Commission Order
ACP-324064-26

Planning Register Reference Number: S5.25.45

WHEREAS a question has arisen as to whether the alteration of the existing stone boundary wall on the grounds of Bishop's House, Old Dublin Road, County Carlow, for the purpose of the installation of a 1.2-meter-high timber gate for the purpose of creating a new opening is or is not development or is or is not exempted development:

Figure 2.1: Existing and proposed elevations of stone wall. (Source: Eugene Keyes c/o Bishop's House, Carlow).

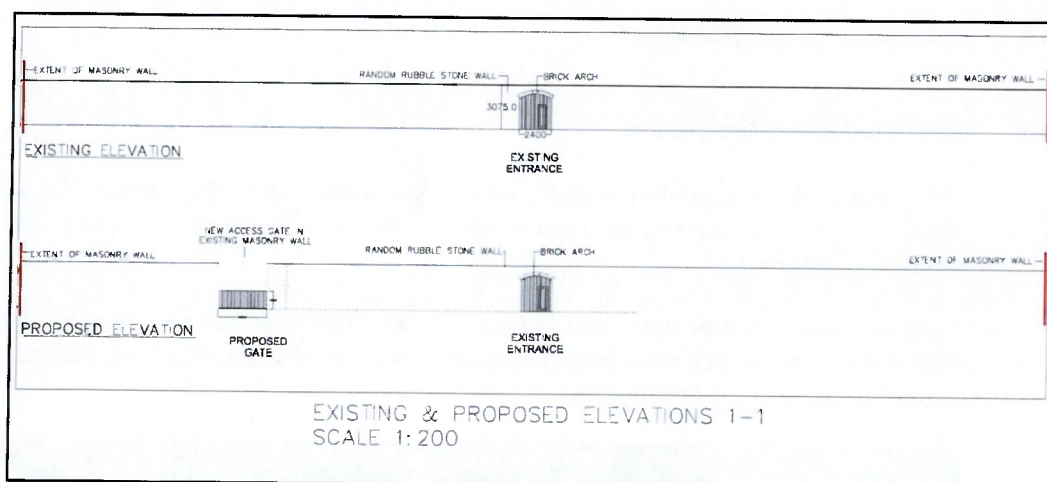
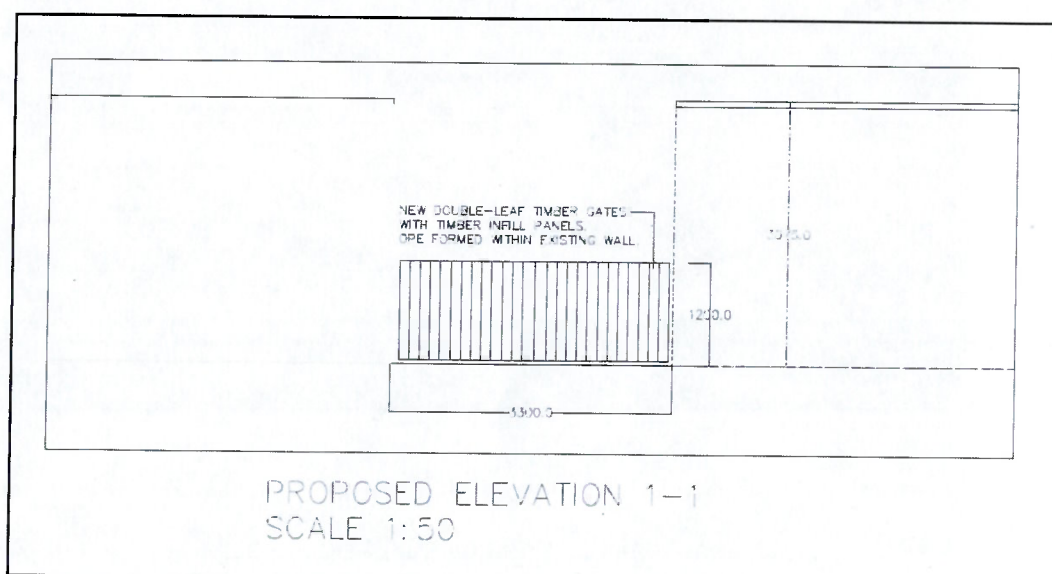
- (a) The alteration of the stone boundary wall, for the purposes of creating a new opening in the wall, constitutes the construction of a gateway which constitutes works and which in turn constitutes development within the meaning of the Planning and Development Act 2000, as amended,
- (b) The height of this constructed gateway would be 3.075 metres (arising from the height of the existing boundary wall and by reference to the submitted drawing number 24001-002 PL1),

- (c) The proposed gateway would not benefit from an exemption by reference to Section 4(1)(h) of the Planning and Development Act, 2000, as it would materially affect the external appearance of the boundary wall so as to render the appearance inconsistent with the character of the remaining wall structure along the Old Dublin road frontage,

- (d) The Conditions and Limitations as set out in Column 2 of both Class 5 and Class 9 of Part 1 of Schedule 2 the Planning and Development Regulations 2001, as amended, includes a height limitation of two metres on such gateways,

- (e) As the gateway height exceeds the limitations set out in Column 2 of both Class 5 and Class 9 of Part 1 of Schedule 2 of the Planning and Development Regulations 2001, as amended, the development does not come within the scope of either Classes 5 or 9 of Part 1 of Schedule 2 of the Planning and Development Regulations 2001, as amended, or any other class or provision of the regulations.
